Subject: DOCO comments for application 2026/91649 at The Coach & Horses, Eastgate, Honley, Holmfirth, HD9 6PA

Re: 2026/91649- Discharge of details reserved by conditions 8 (access signage/white lining markings), 15, 16, 17 (drainage), 18 (crime/security), 19 (landscaping), 20 (materials), 22 (windows), 23 (doors) on previous permission 2025/93126 for demolition of rear block, erection of rear extensions and alterations to existing building to form 9 apartments including associated works and alterations (within a Conservation Area) at The Coach & Horses, Eastgate, Honley, Holmfirth, HD9 6PA

Description
SITE PLAN CRIME + SECURITY

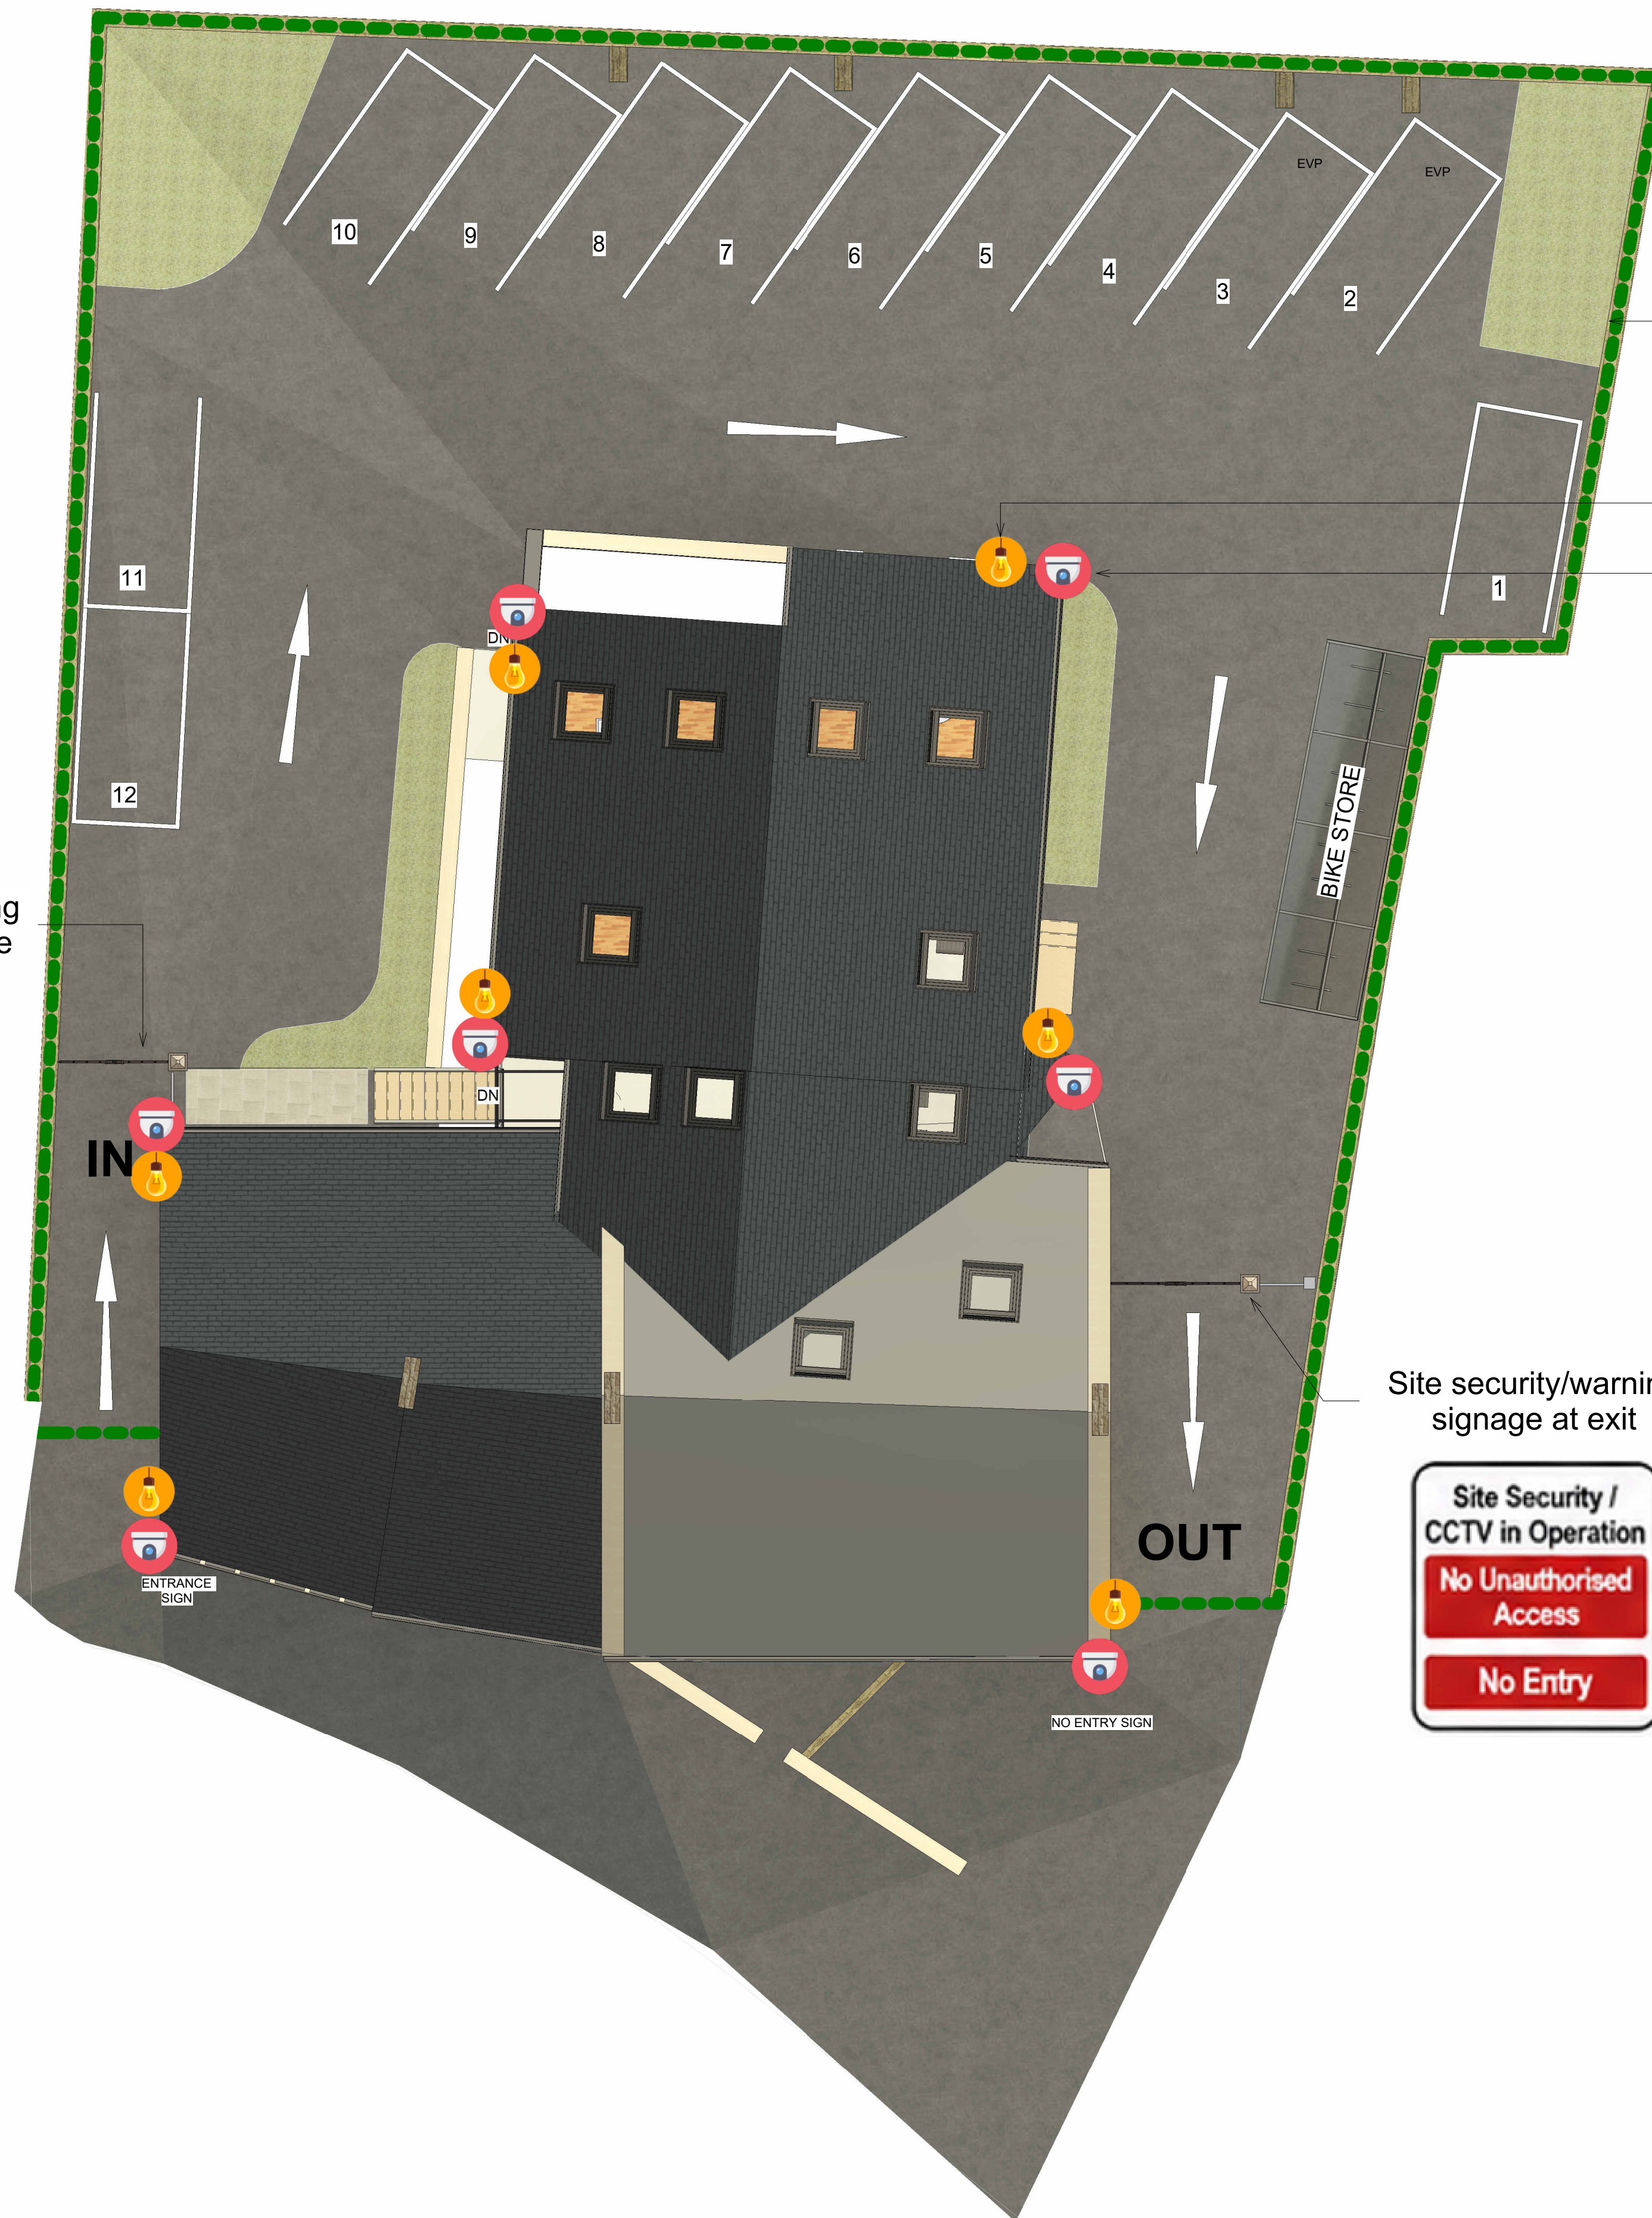
- a. Could the applicant be provided with the following general advice with regard to temporary perimeter fencing, please:
Heras fencing panels should be of rigid mesh (not lightweight mesh) specification, joined with anti-tamper couplers and feature weighted support feet. Padlocks and chains used to secure gates should be tested to one of the Police preferred specifications, either Sold Secure Gold (chains and padlocks) or LPS 1654 (padlocks), both of which offer a higher attack resistance. When locked, the padlock should be positioned to remove any slack in the chain, preventing the gate from being partially opened or the chain being used as a climbing aid.
- b. PIR lighting is not supported from a designing out crime perspective due to operational inefficiencies. Could this be replaced with dusk till dawn lighting, please.

Measures listed in points a, c, d and e are acceptable. Ideally, lighting arrangements (point b) should be amended as above.
